Your ref: SSD-48160216  
Our ref: DOC24/736122-1

**Subject: Maison Dieu Solar Farm**

Thank you for your Major Projects Portal request dated 6 September 2024 seeking advice from the Biodiversity, Conservation and Science (BCS) Group of the NSW Department of Climate Change, Energy, the Environment and Water (DCCEEW) on the Maison Dieu Solar Farm Environmental Impact Statement (EIS).

## Attachment 1 - BCS Comments

Figure 4 Native vegetation extent

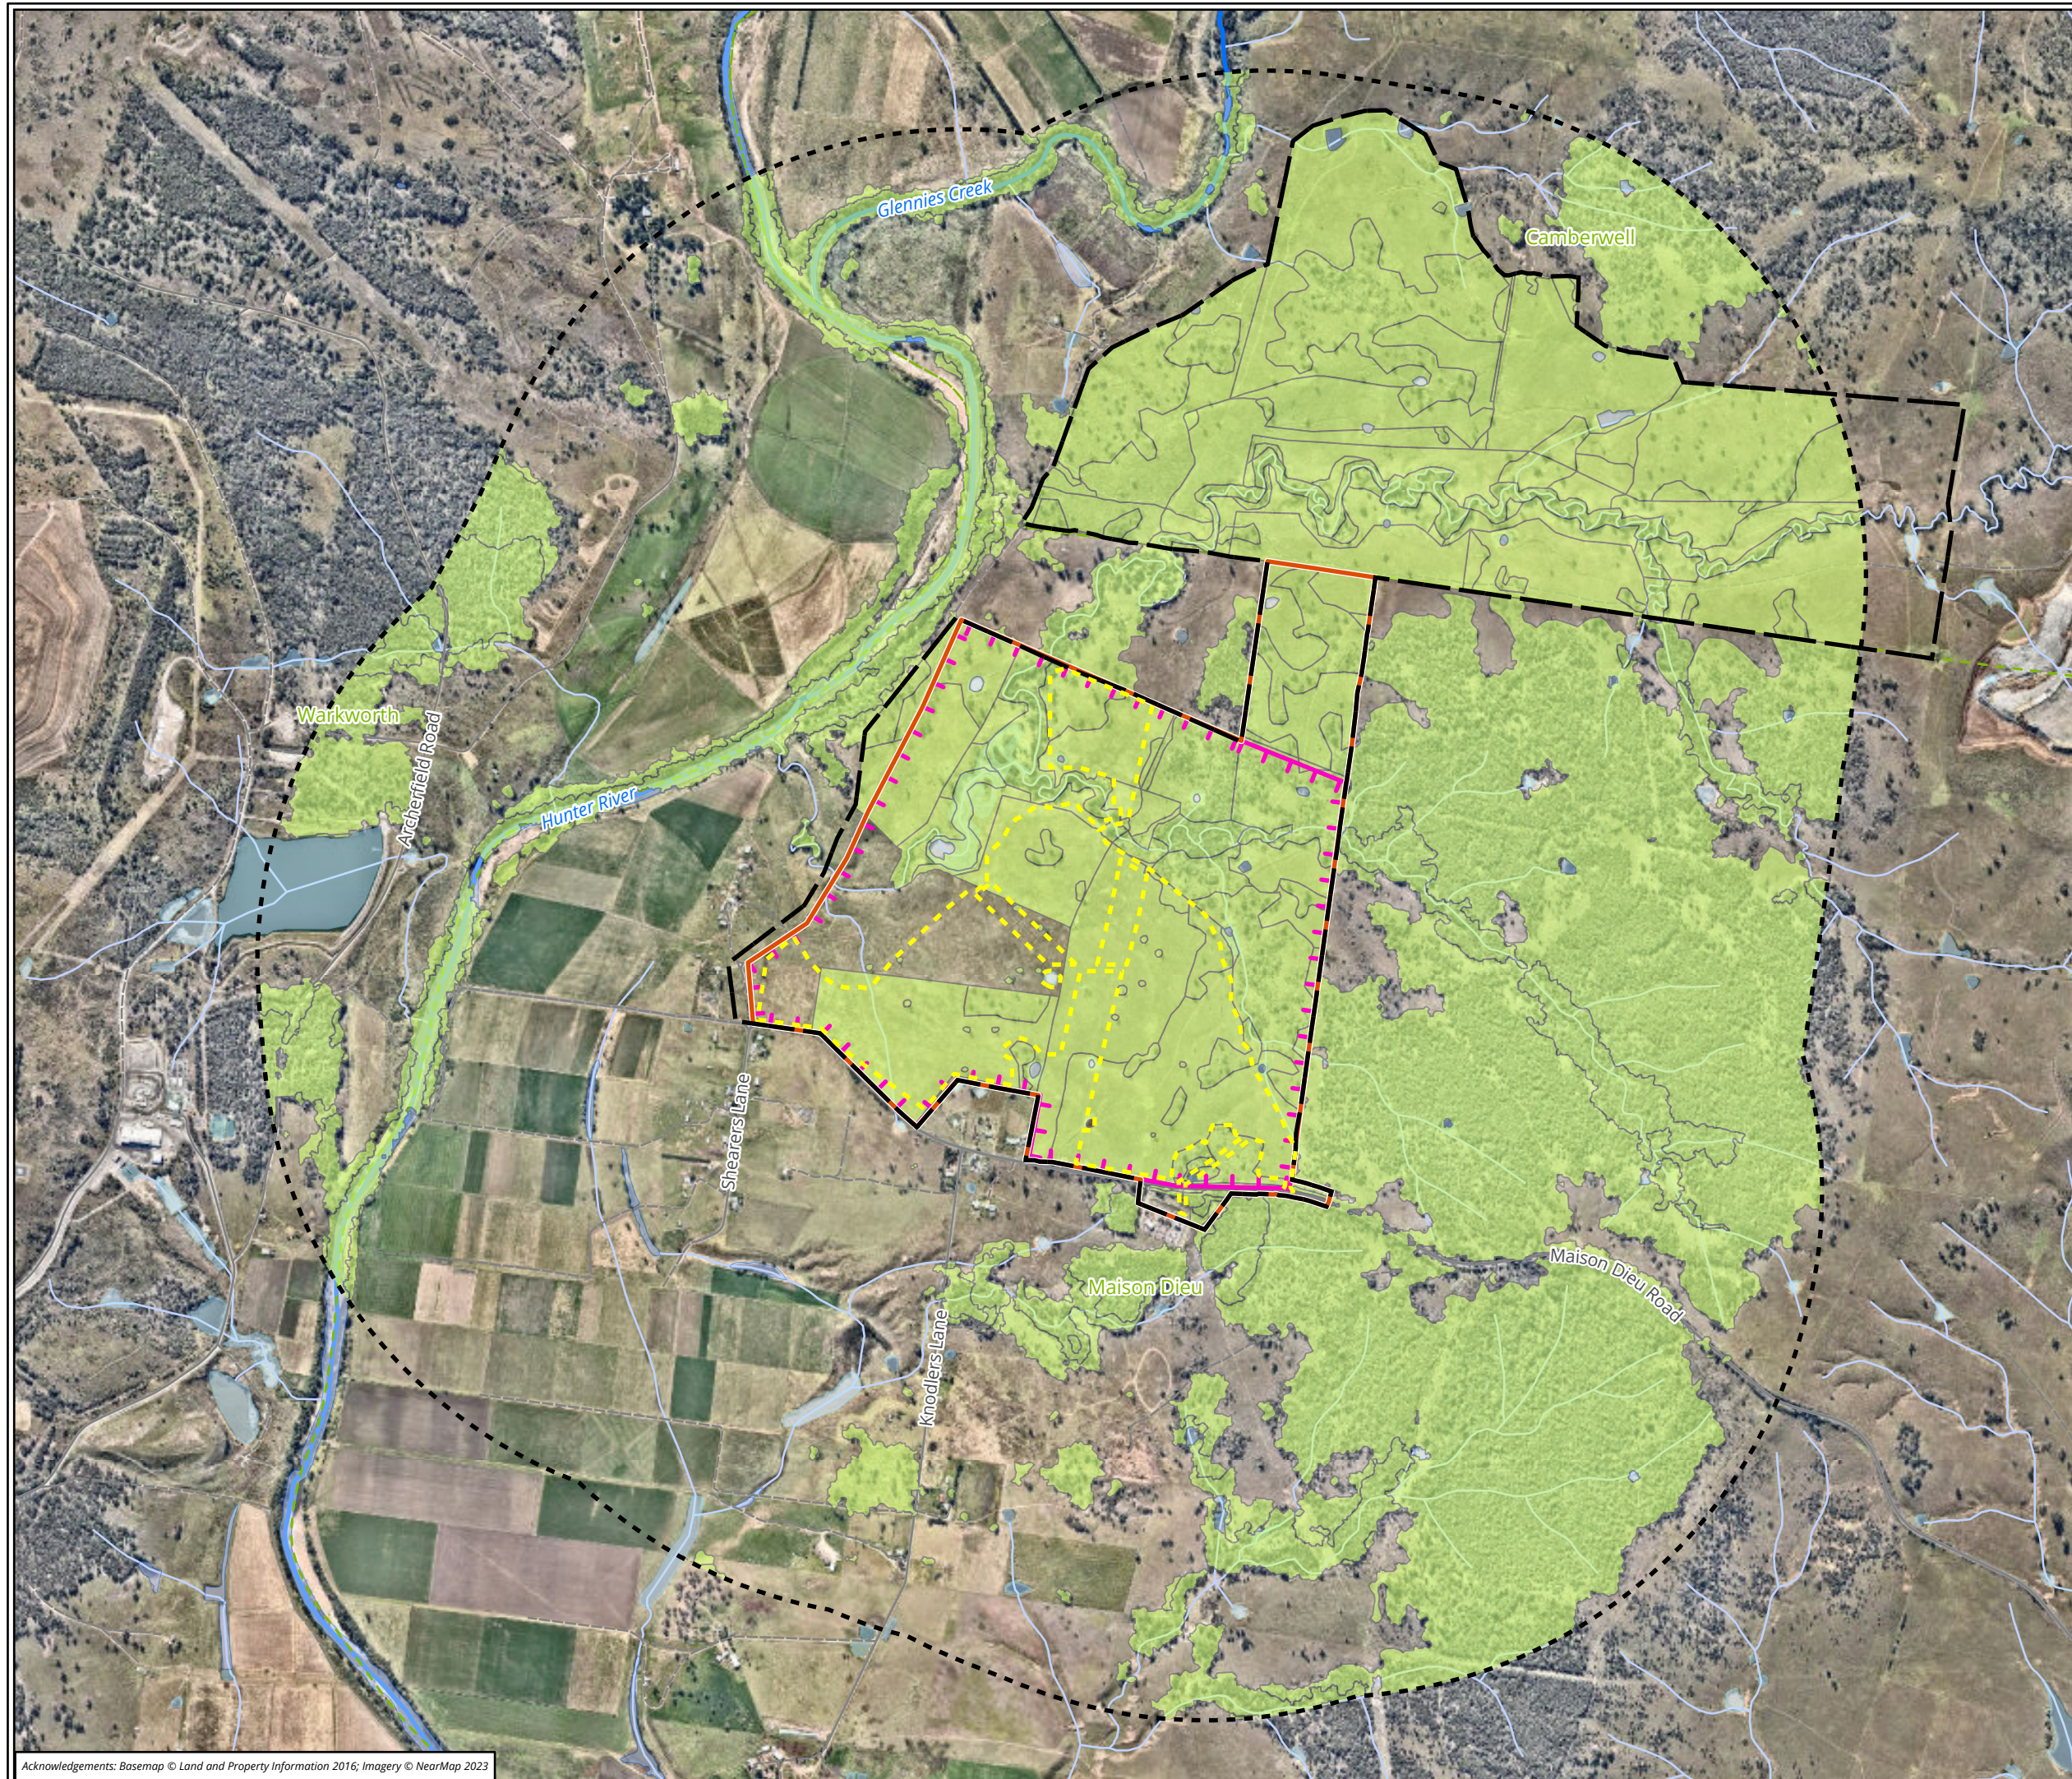
1.	LLS Land categorisation assessment not adequate	<p>A significant portion of the Subject Land has been classified as Category 1 land, and therefore exempt from further assessment under the Biodiversity Offsets Scheme (BOS). It is not clear in the BDAR the assessment process used to determine this categorisation, such as how applicable criteria in the <i>Local Land Services Act 2013</i> (LLS Act) and Regulation have been met and the application of the Interim Grasslands and Groundcover Assessment Method.</p> <p><b>Recommended action:</b></p> <p><i>Provide details of how Category 1 land was determined, in accordance with criteria specified in the LLS Act and Regulation, and results of fieldwork undertaken in accordance with the Interim Grasslands and Groundcover Assessment Method.</i></p>
	<i>Extent and Timing</i>	Pre-determination

Figure 15 Estimated zones of indirect impact for the proposal

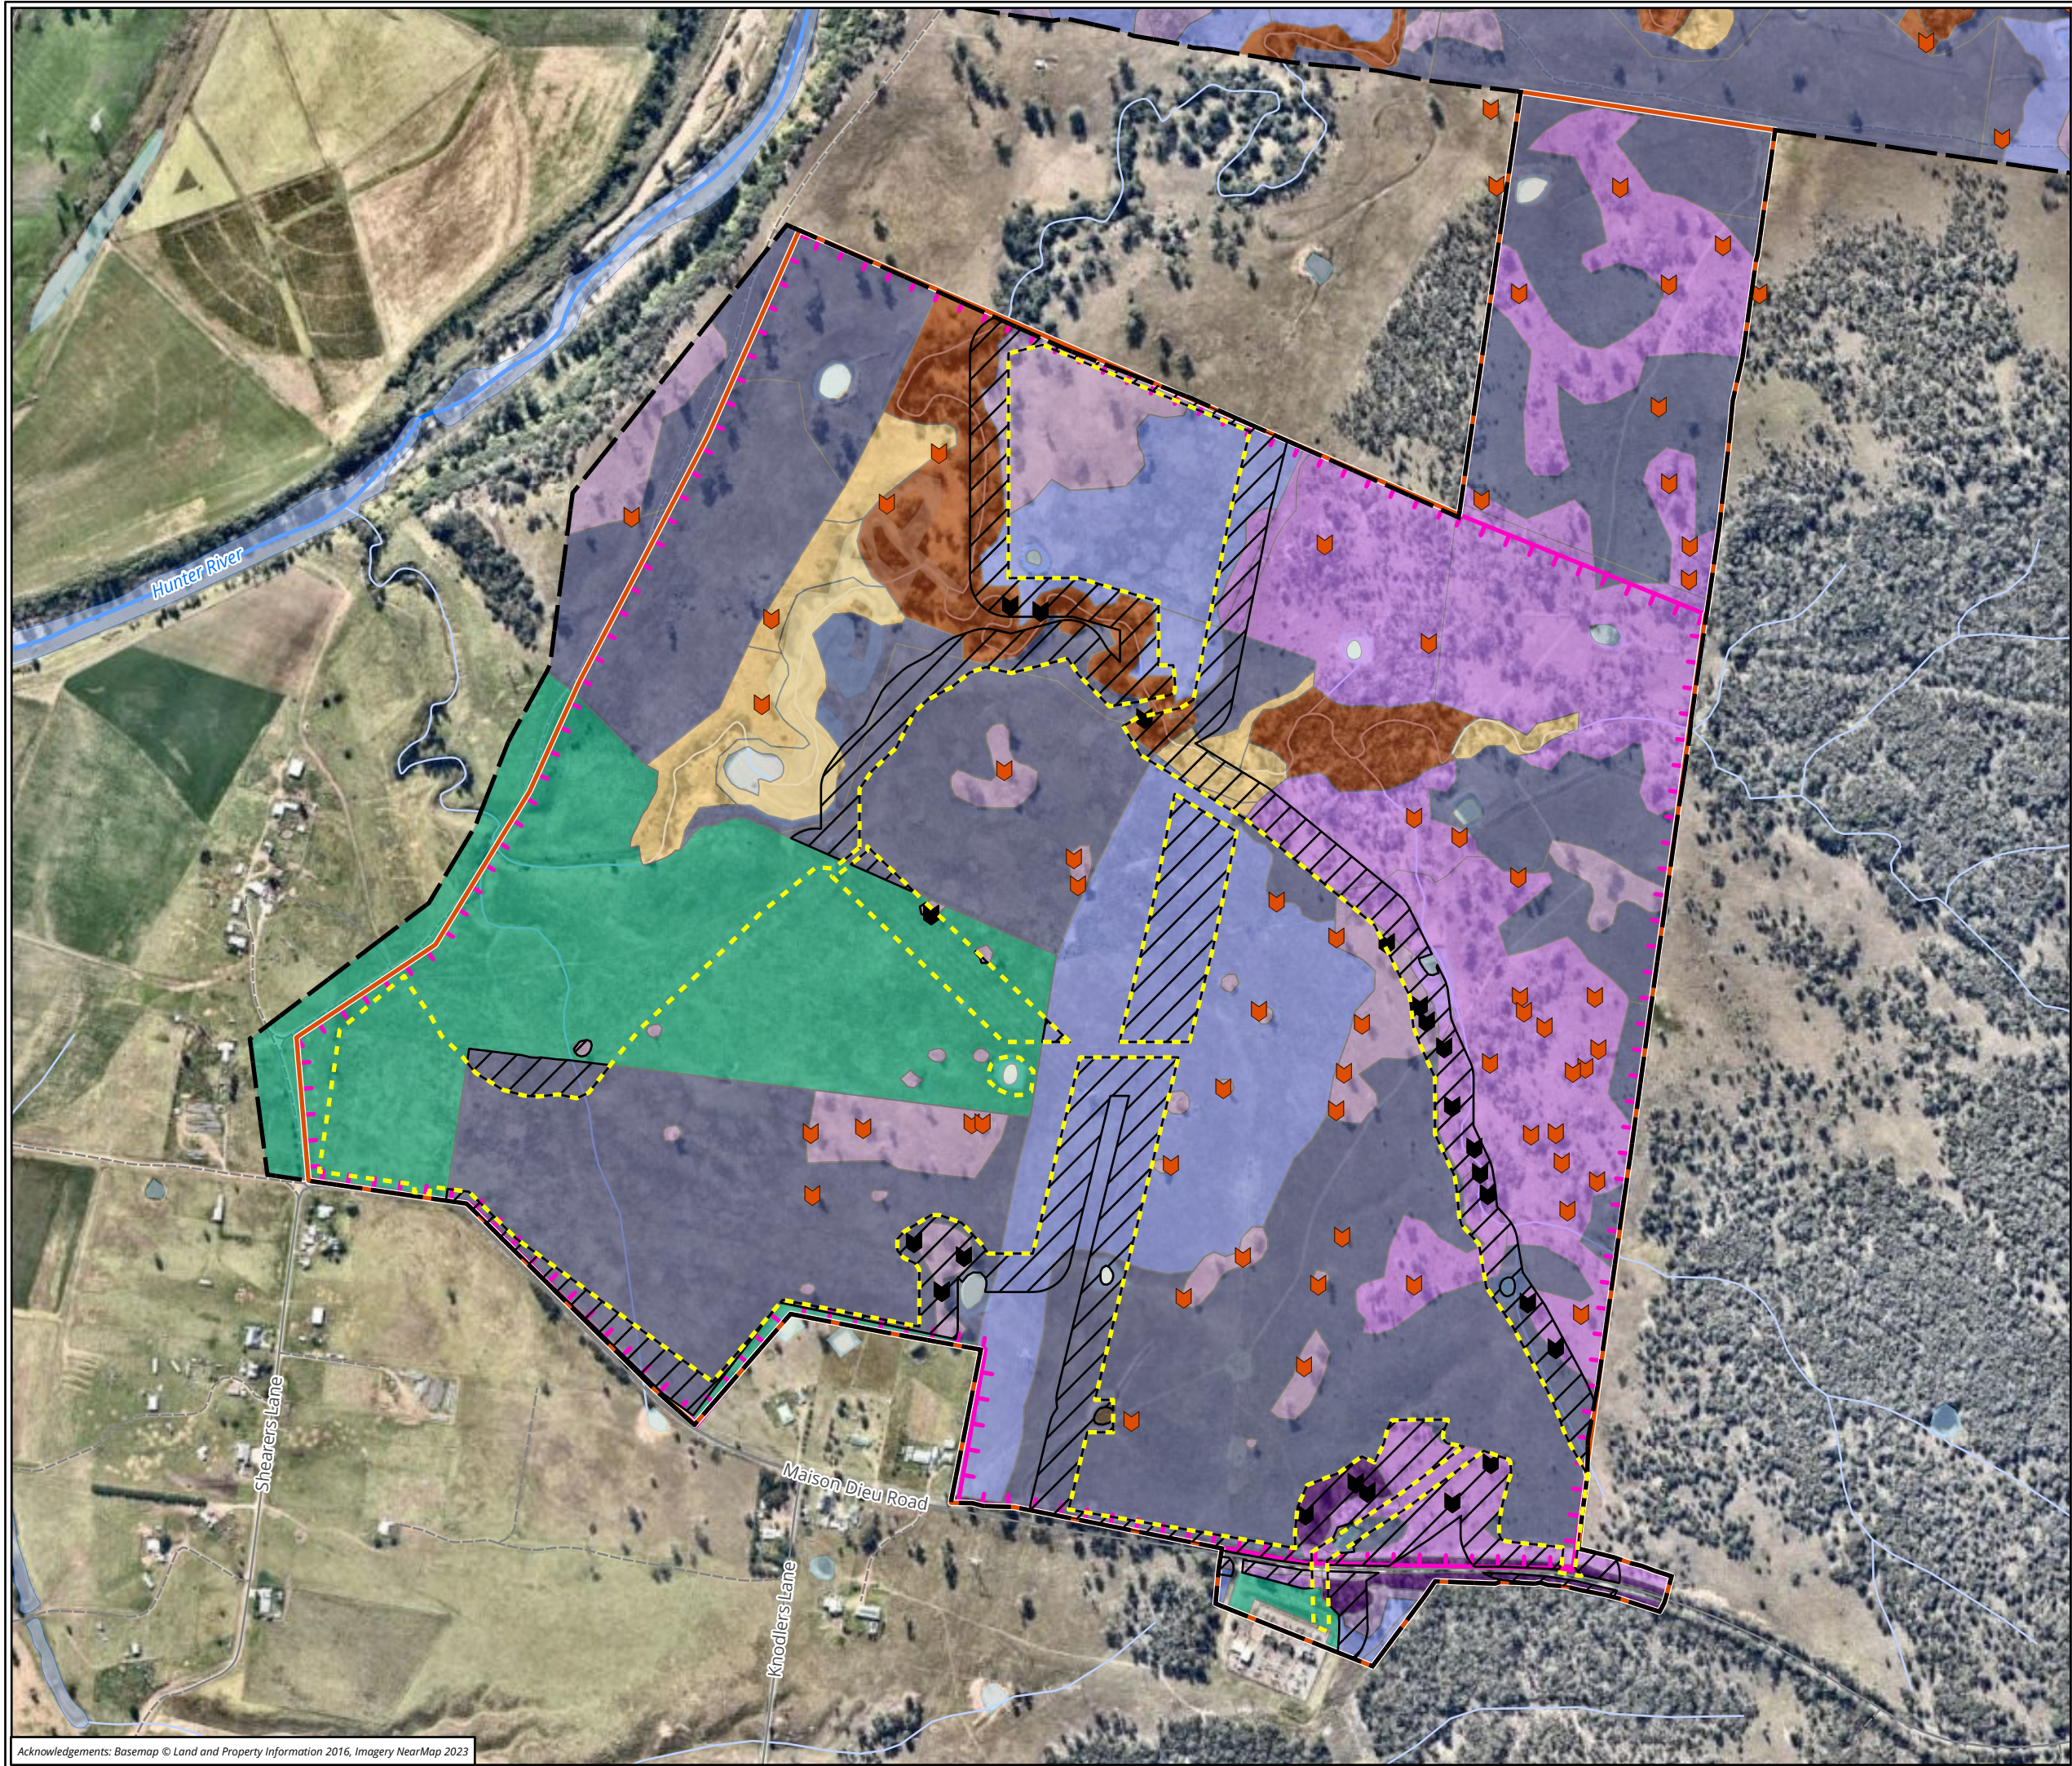
16.	Further detail required on the assessment of indirect impacts	<p>The extent of potential indirect impacts is shown in the BDAR as a 30m buffer from the edge of the Disturbance Footprint. Table 40 in the BDAR refers to measures contained within a CEMP to address indirect impacts, however this is not suitable to manage long term operational indirect impacts.</p> <p><b>Recommended action:</b></p> <p><i>Additional details are required detailing proposed measures in a BMP to adequately manage the indirect impacts in Table 40. Otherwise, a partial loss of vegetation integrity (VI) within the 30m buffer should be assumed and additional credits estimated accordingly in accordance with S2.4.1 of the BAM Operational Manual Stage 2.</i></p>
	<i>Extent and Timing</i>	Pre-determination
